re: **Grading Plan Review**
Proposed Commercial Building Addition
2 Bill Leathem Drive - Ottawa

file: PG5257-MEMO.05

- ☐ Lot Grading and Drainage Plan, Project No. CP-20-0023-01, Drawing C101, Revision 2 dated May 24, 2022.

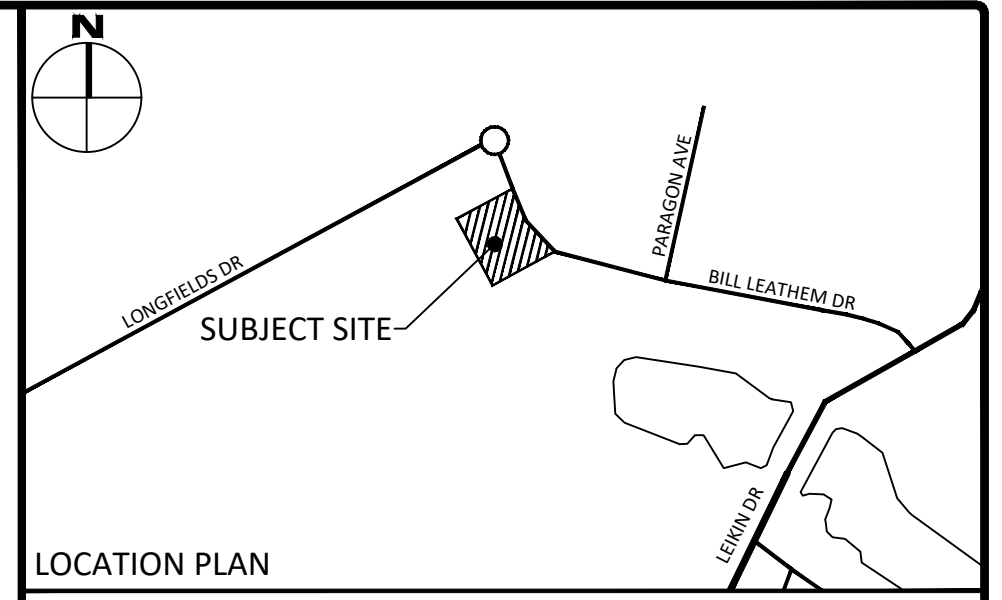
Based on our review of the above noted plans, it is understood that the finish floor level FFL for the proposed building addition will be at geodetic elevation 91.7m. In addition, the USF of the proposed building addition will be at geodetic elevation 90.18m. It is further understood that there is an existing manhole MH7 located in close proximity to the central portion of the proposed northern foundation wall of the building addition.

Based on our review of the available information and drawings, it is understood that the horizontal separation between MH7 and the central portion of the northern foundation wall is approximately 0.8m. Also, the vertical separation between the invert level of MH7 and the USF of the proposed building addition is 2.7m.

Based on our review, the lateral support zone of 1.5H:1V for the proposed building addition adjacent to the existing manhole is not protected. Therefore, the USF of the effected footings should extend down to the bottom level MH7 or it can be placed on a near vertical lean concrete infill trench (17MPa, 28-day compressive Strength). The lean concrete infill trench shall extend a minimum 150mm from the face of the footing on each side. Furthermore, the lean concrete infill trench shall extend at least 2.0 from the face of MH7 from each side. The lean concrete trench can then be stepped upward at a slope of 1H:1V. Further details are provided on Figure 1 –Concrete infill trench detail, attached to this memorandum.

A perimeter drainage system consisting of a minimum 150mm perforated corrugated PVC pipe should be installed at USF level, around the exterior side of the proposed building addition, below the sidewalk, and directed to a storm sewer.
